Conversion & extension of dwelling comprising two existing flats to form 6 No. flats (4 No. new) with associated ancillary services.

75 Highfield Road Bognor Regis

Thank you for your internet representation made on 18th January 2019 which has been recorded as '**an objection**' with the comments as follows:

Site Plan (Proposed) 1:200

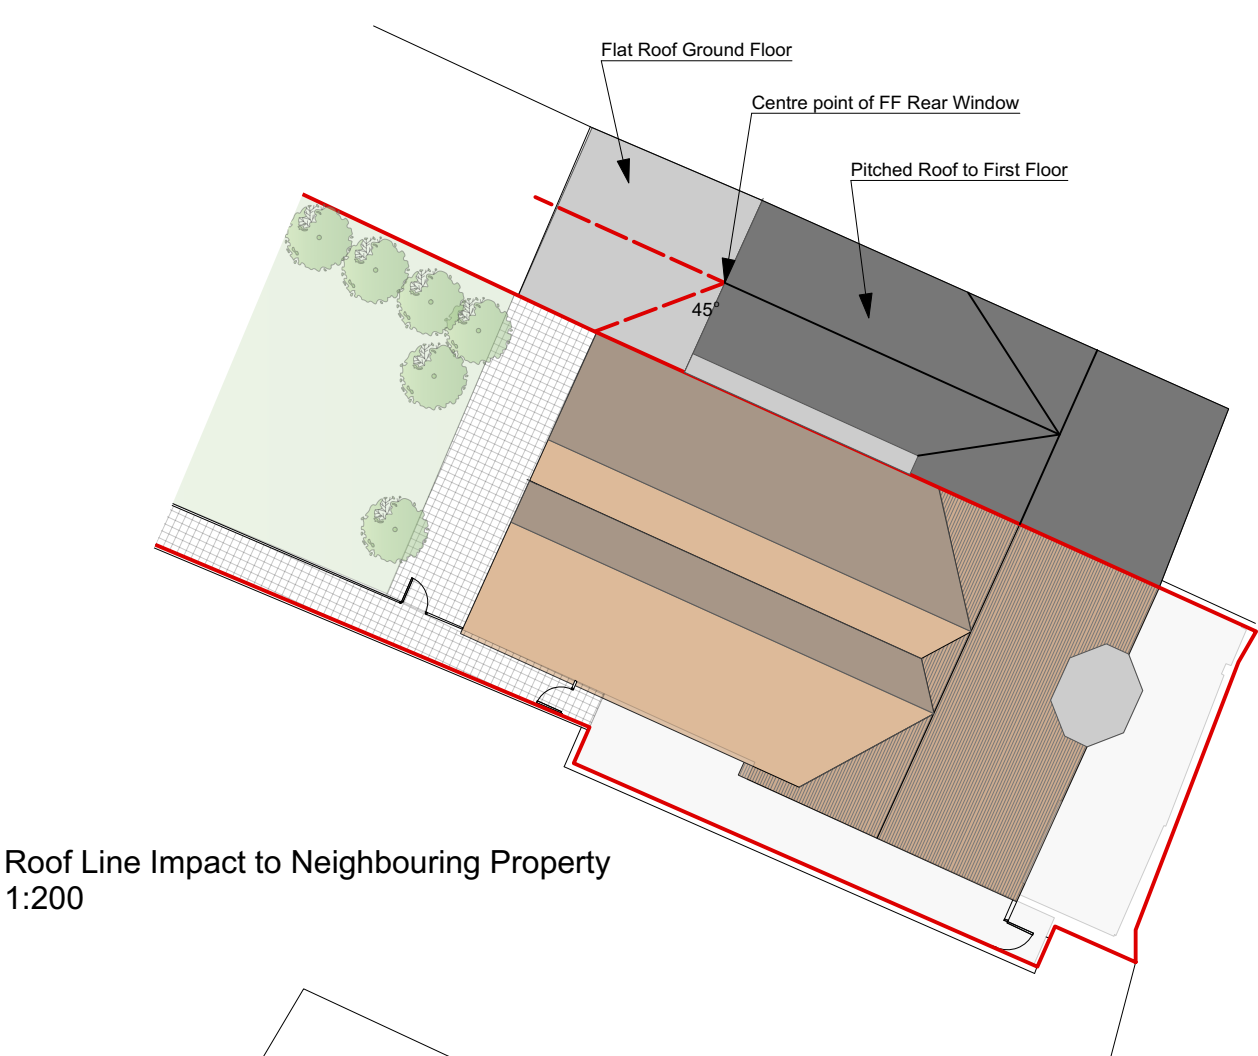
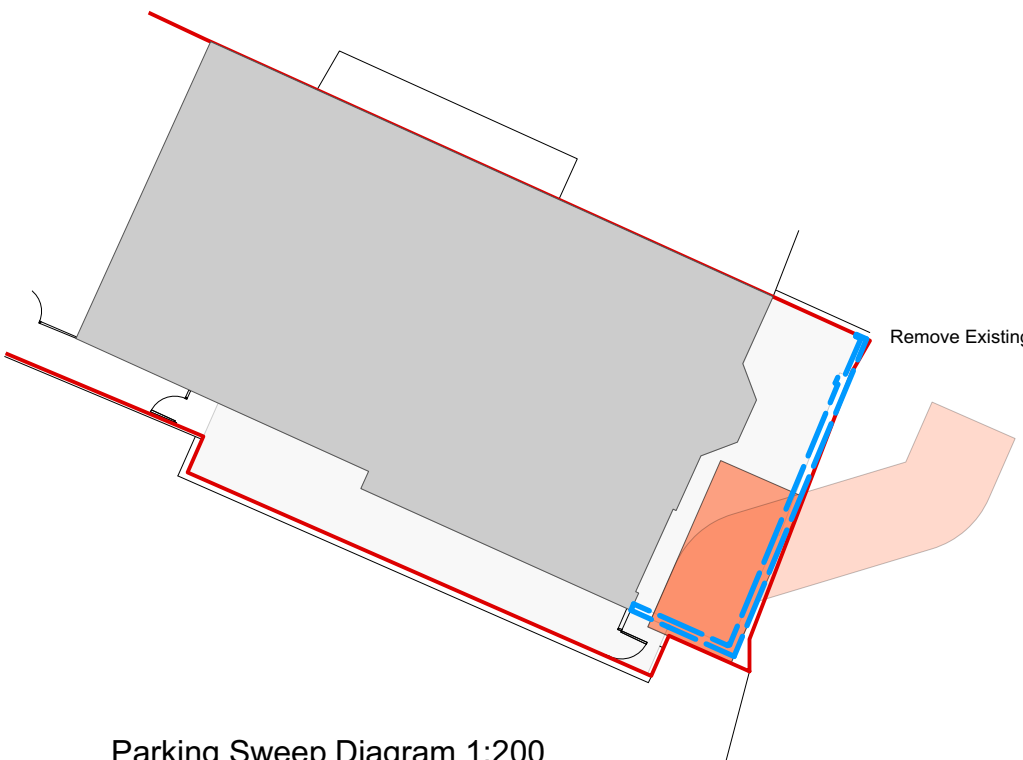
again after looking at the amended plan for 75 highfield road there is only 1 parking slot available , totally unrealistic to expect another 10 cars or so to park in a road which is already congested and dangerous especially where the new 6 flats are proposed to go , so will be appealing this should it go through as I feel no consideration for existing residents has been made or understood ,
